RE: Blue Sky Short Plat (SP-10-00003)

The Kittitas County Community Development Services Department has determined that the Blue Sky Short Plat (SP-10-00003) is a complete application and hereby grants *conditional preliminary approval* subject to the following conditions:

SUBJECT: Blue Sky Short Plat SP-10-00003

BLUE SKY SHORT PLAT
A PORTION OF THE SOUTH 1/2 OF SEC. 29 T.20N., R.16E., W.M.
KITITAS COUNTY, WASHINGTON

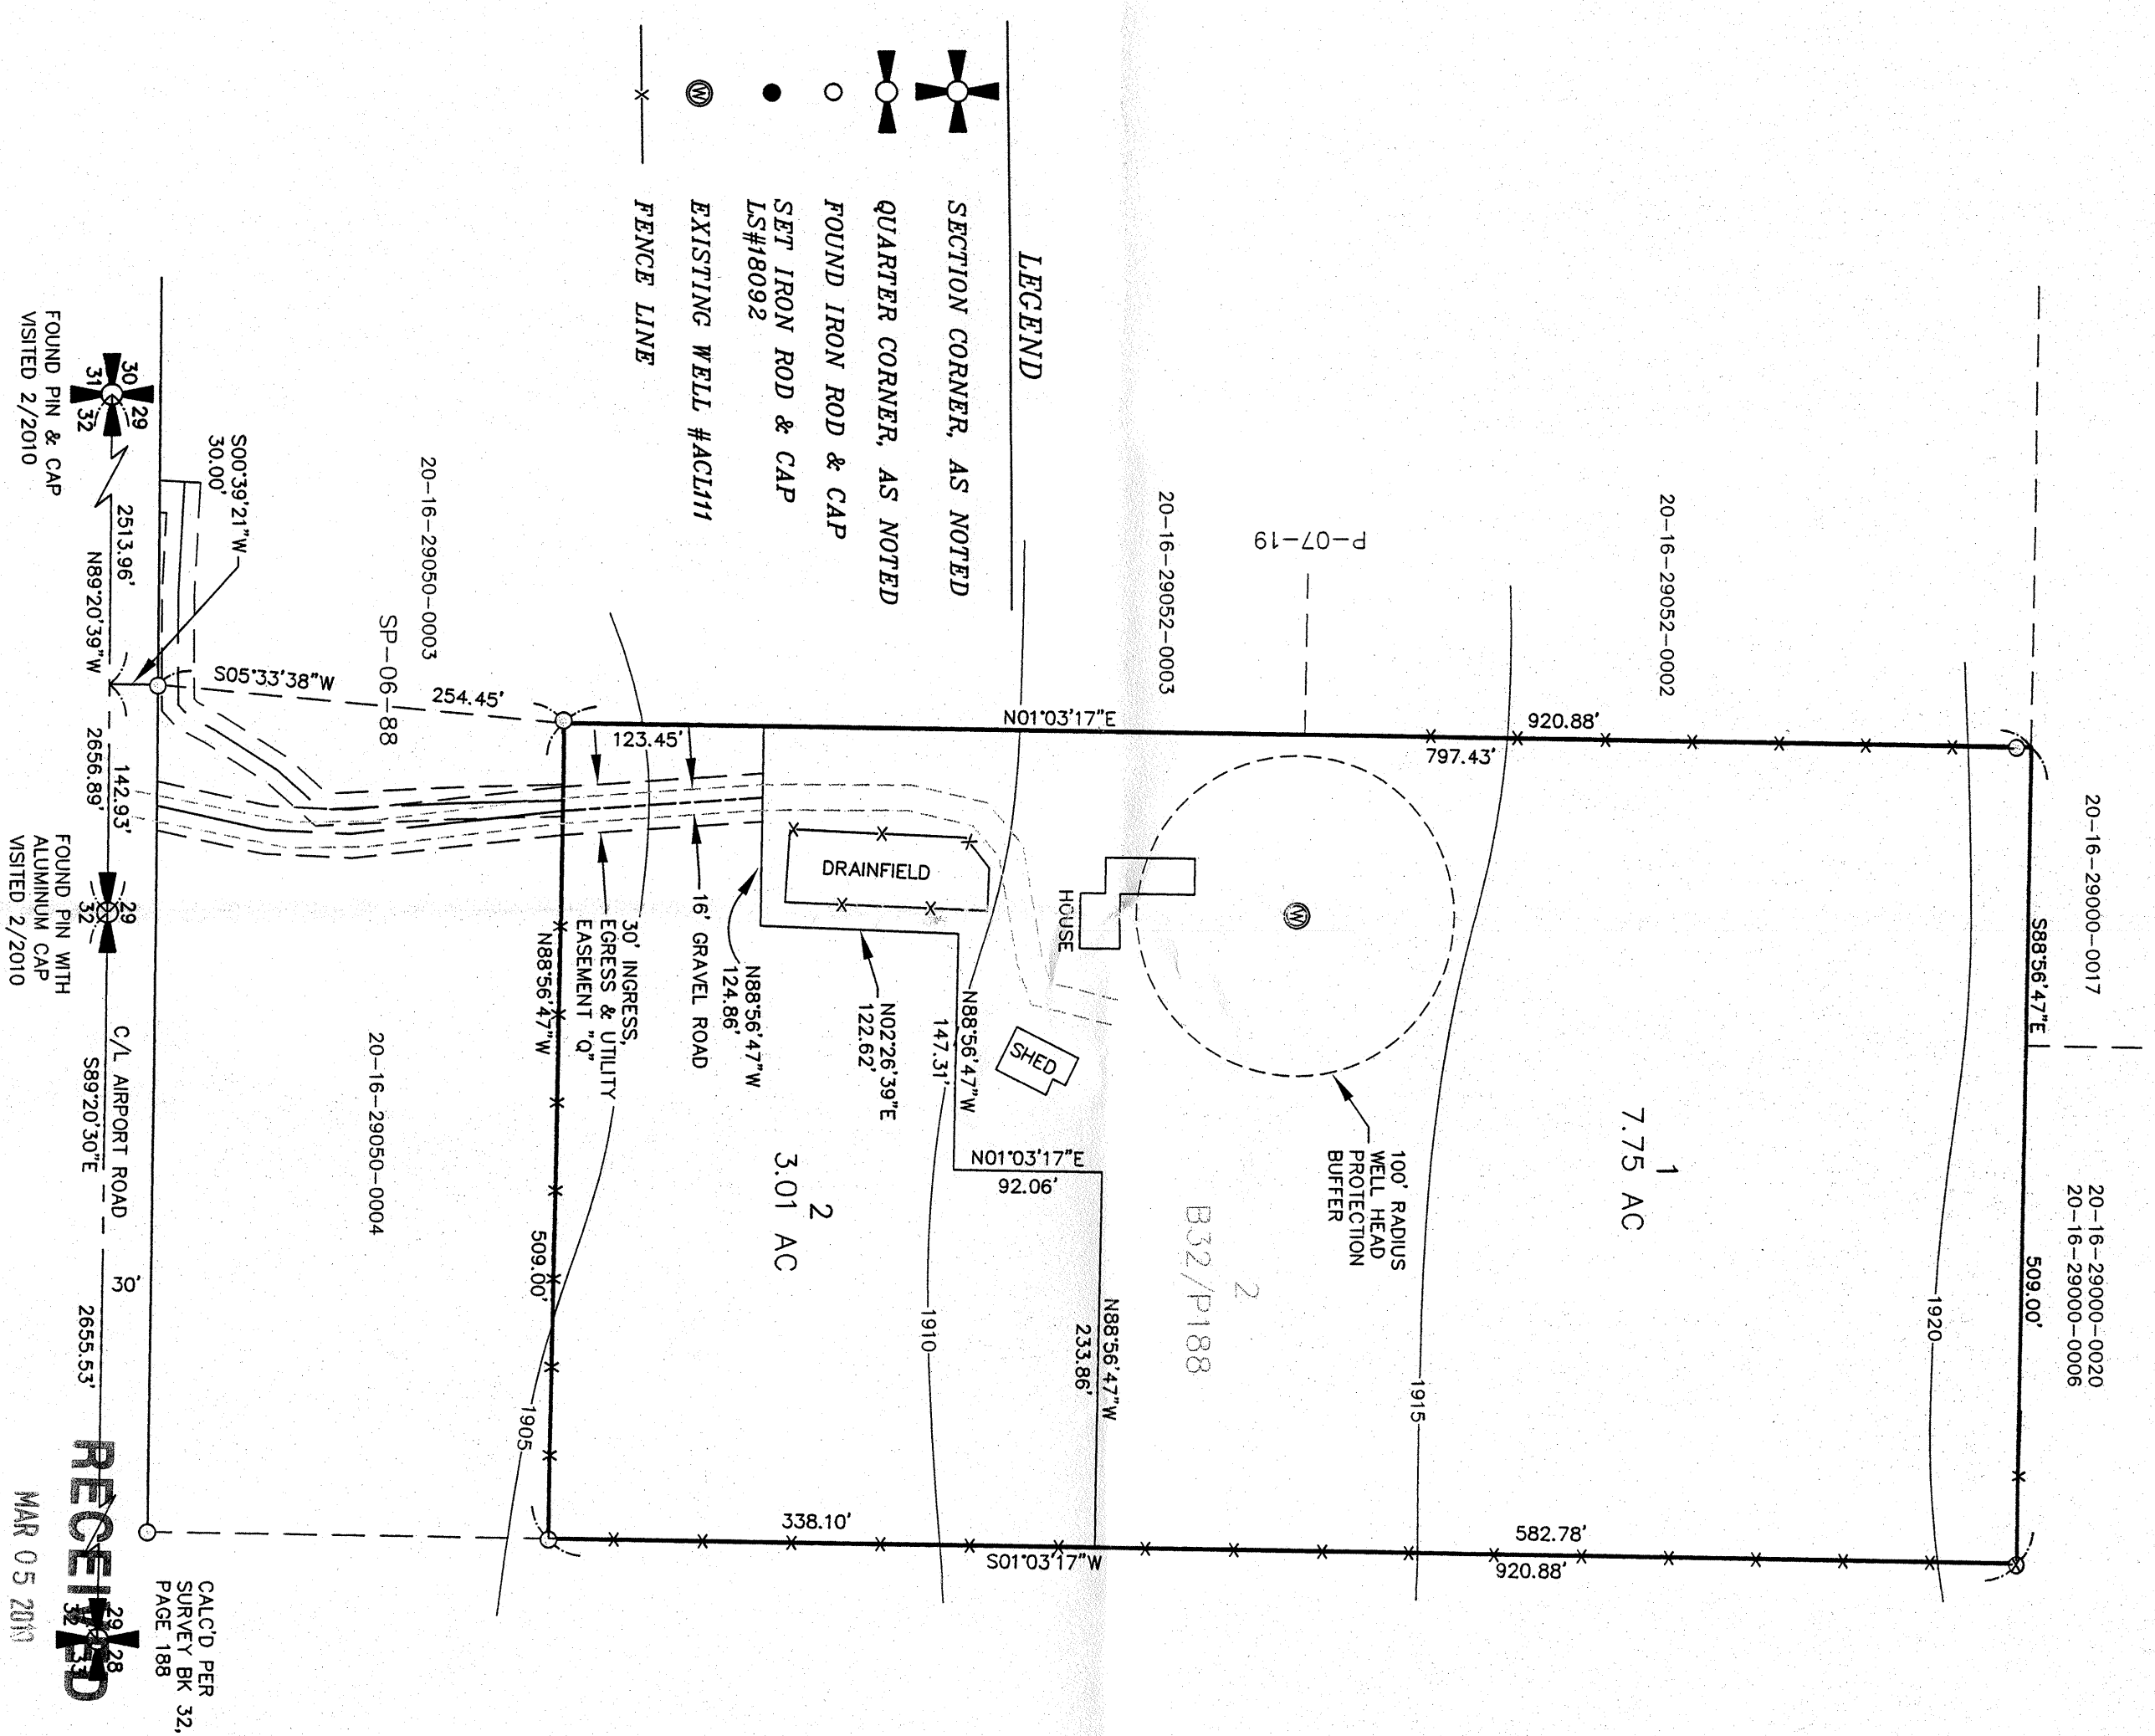
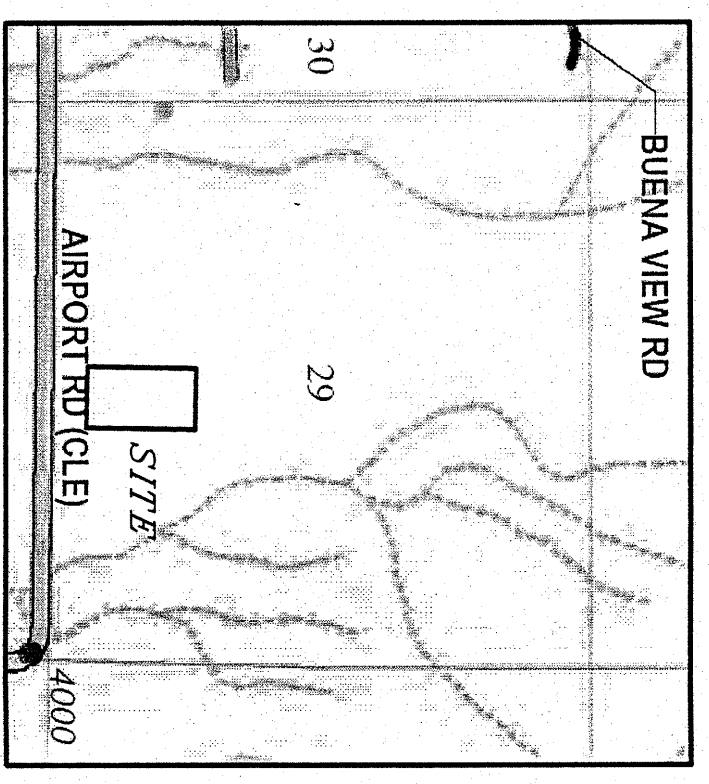
1. Both sheets of the final mylars shall reflect short plat number SP-10-00003 and an accurate legal description shall be shown on the face of the final plat.

3. Variance: All conditions of Road Variance 09-10 shall be met, including the construction of a paved apron, 22' wide gravel road, and all other road standards requirements.

4. Private Road Improvements: Access from Airport Road to the cul-de-sac shall be constructed to meet or exceed the requirements of a High-Density Private Road that serves 3-14 tax parcels. See Kittitas County Road Standards, 9/6/05 edition.

- a. Access easements shall be a minimum of 40' wide. The roadway shall have a minimum width of 20', with 1' shoulders, for a total width of 22'.
 - b. Minimum centerline radius will be 60'.

5. Cul-de-Sac: A cul-de-sac turn-around having an outside right-of-way or easement diameter of at least 110 feet shall be constructed at the closed end of all dead-end roads serving 3 or more lots. The driving surface shall be at least 96 feet in diameter. Cul-de-sacs must also conform to the requirements specified by the 2006 International Fire Code. Contact the Fire Marshal regarding any additional cul-de-sac requirements.
